Community Services Planning Department

RESPONSE TO COMMENTS MAY 26, 2020

Reference: Aspen Ranch Preliminary Plat

SHEET 17 OF 22

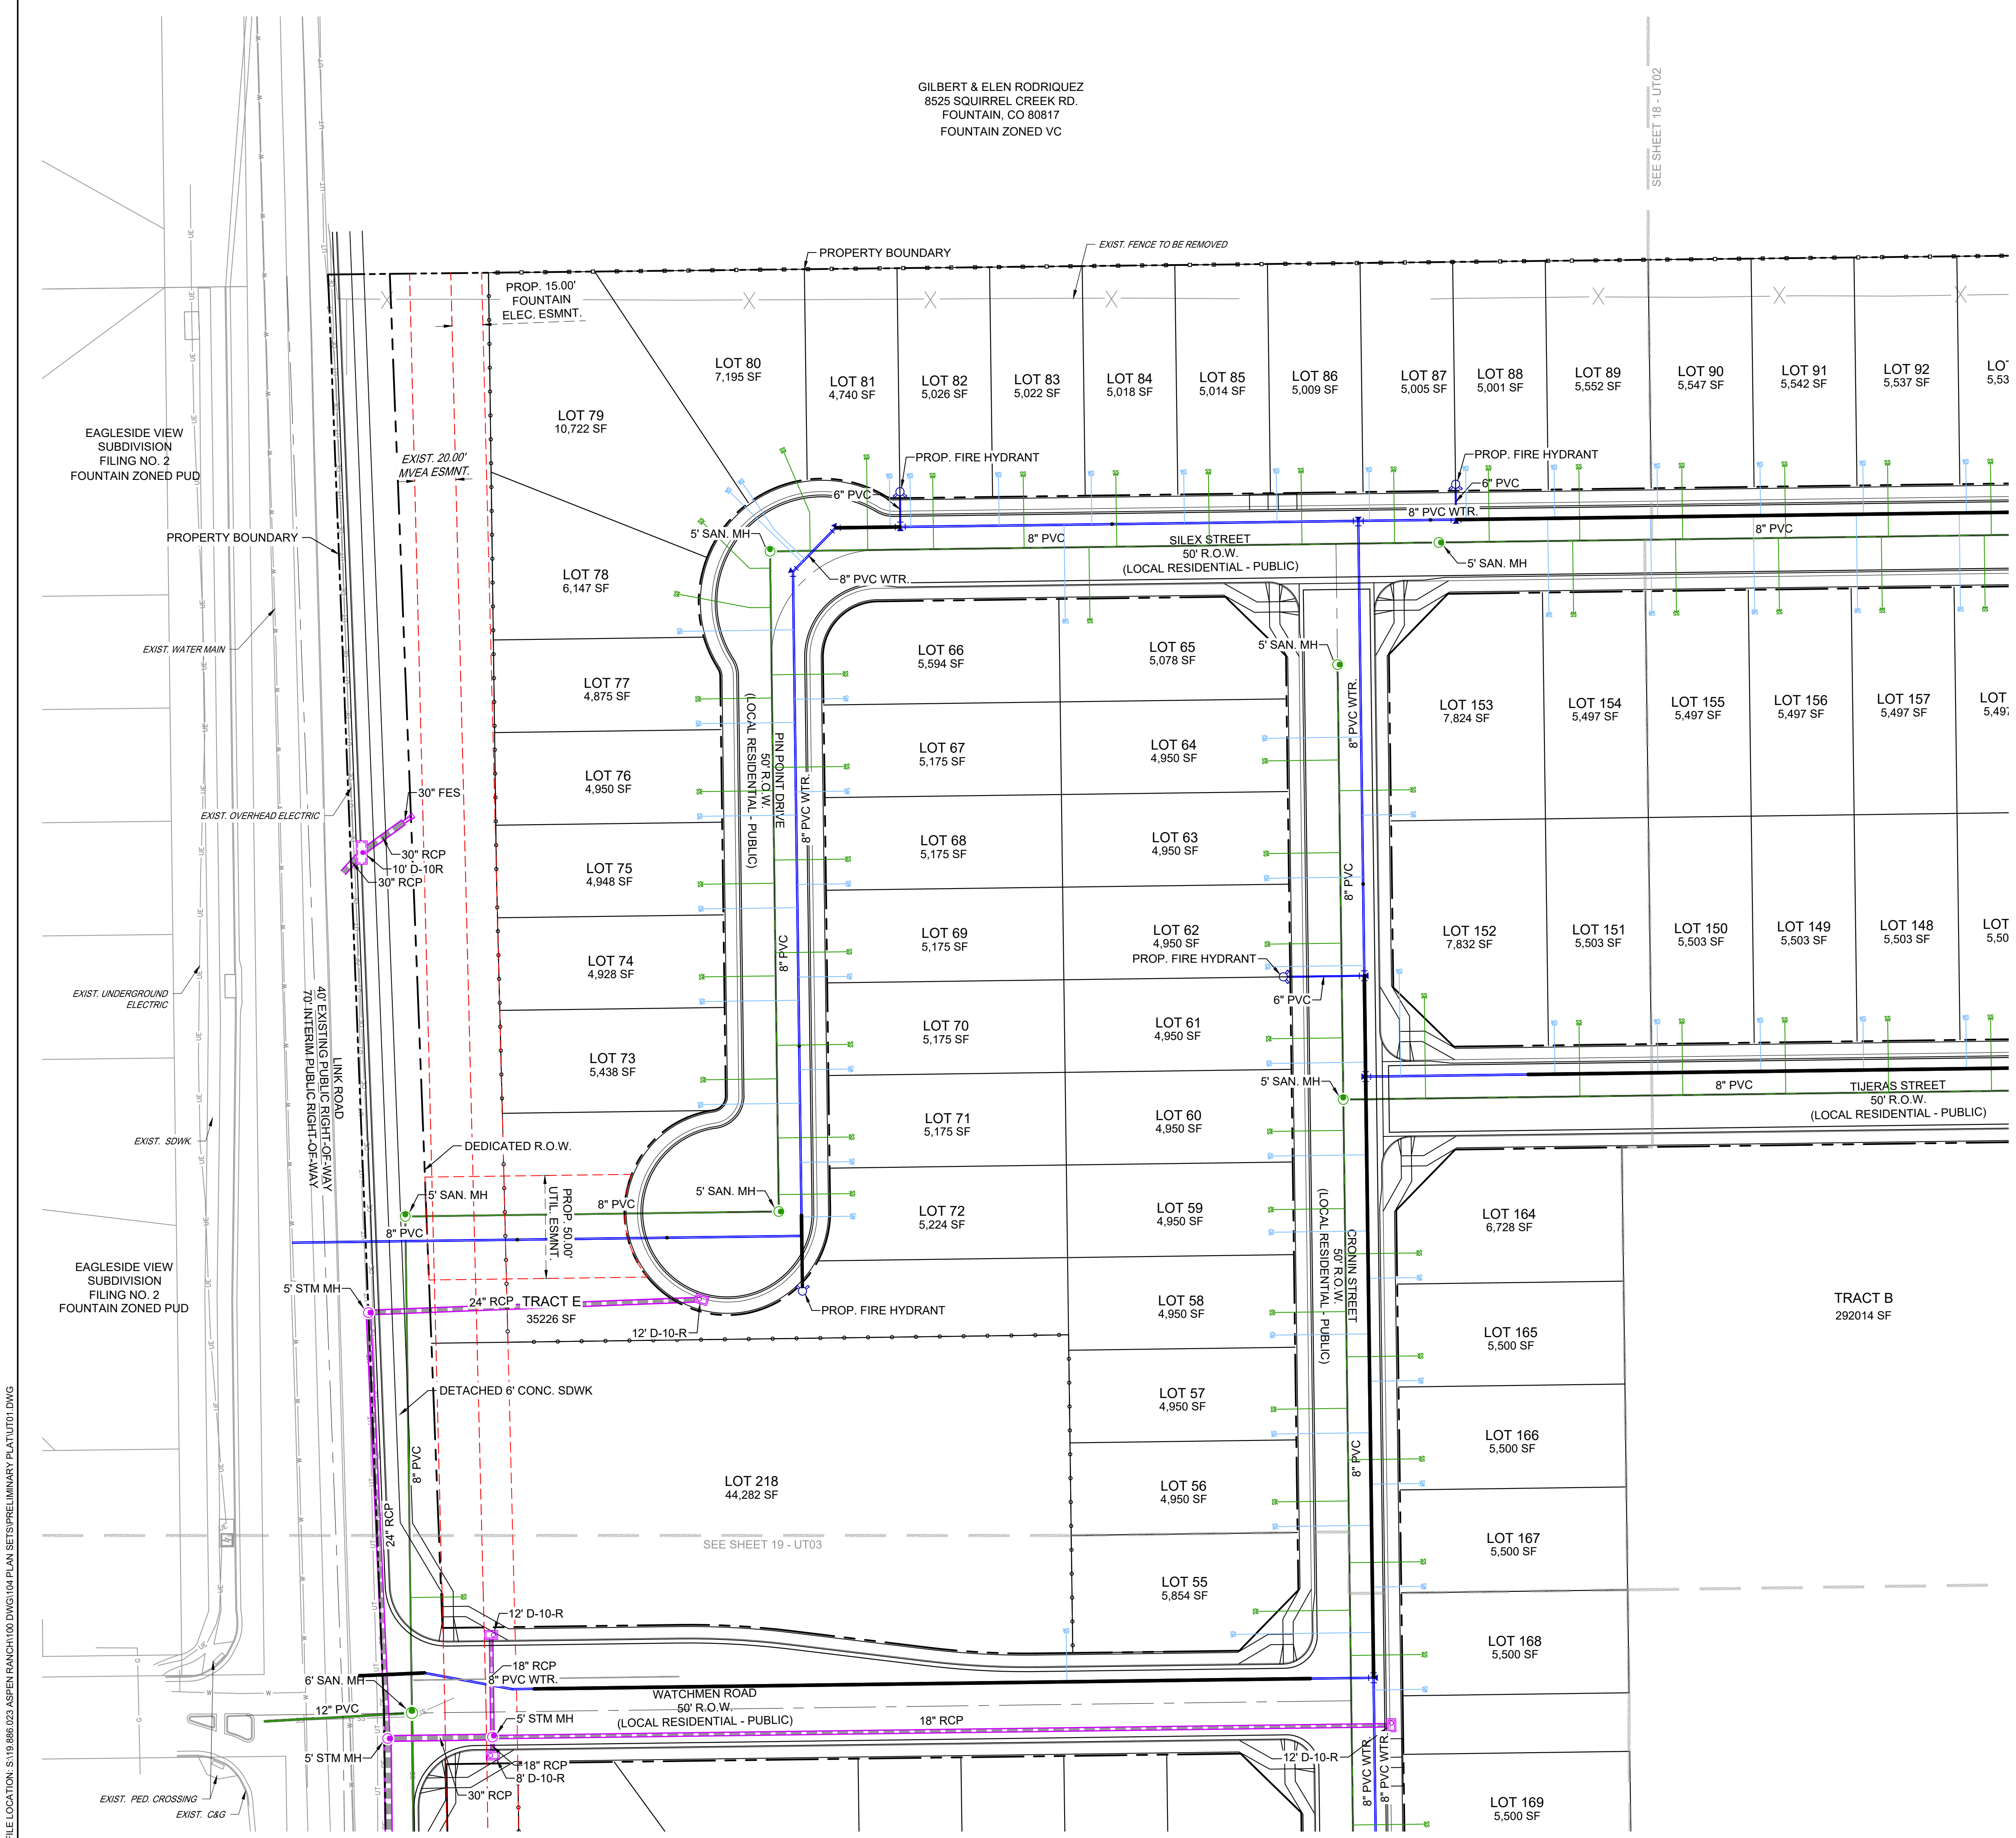
All manholes must be 5' in dia. for connections of 1-2 lines, and 6' in dia. for 3-4 lines connections. **RESPONSE: NOTED, REVISED AS REQUIRED.**

1. Label san. swr. as private or Public **ADDRESSED: ALL SAN. PIPES ARE CALLED OUT APPROPRIATELY**
2. Label san. swr. as existing or proposed **ADDRESSED: ALL SAN. PIPES ARE CALLED OUT APPROPRIATELY**
3. All proposed san. swr. lines need a drivable surface that meets AASHTO H-20 loading **RESPONSE: NOTED, WILL BE INCLUDED WITH FUTURE CD SUBMITTALS.**
4. Add a sheet index map to each page. **ADDRESSED: ALL SHEETS HAVE SHEET INDECES NOW**

5. Why an 8” dia. pipe in Crescent Moon Street? What are the future flows in that area?
RESPONSE: PER DISCUSSION WITH FSD ON 5/12 THE SANITARY PIPE SHALL REMAIN AS SHOWN TO CAPTURE FUTURE FLOWS.
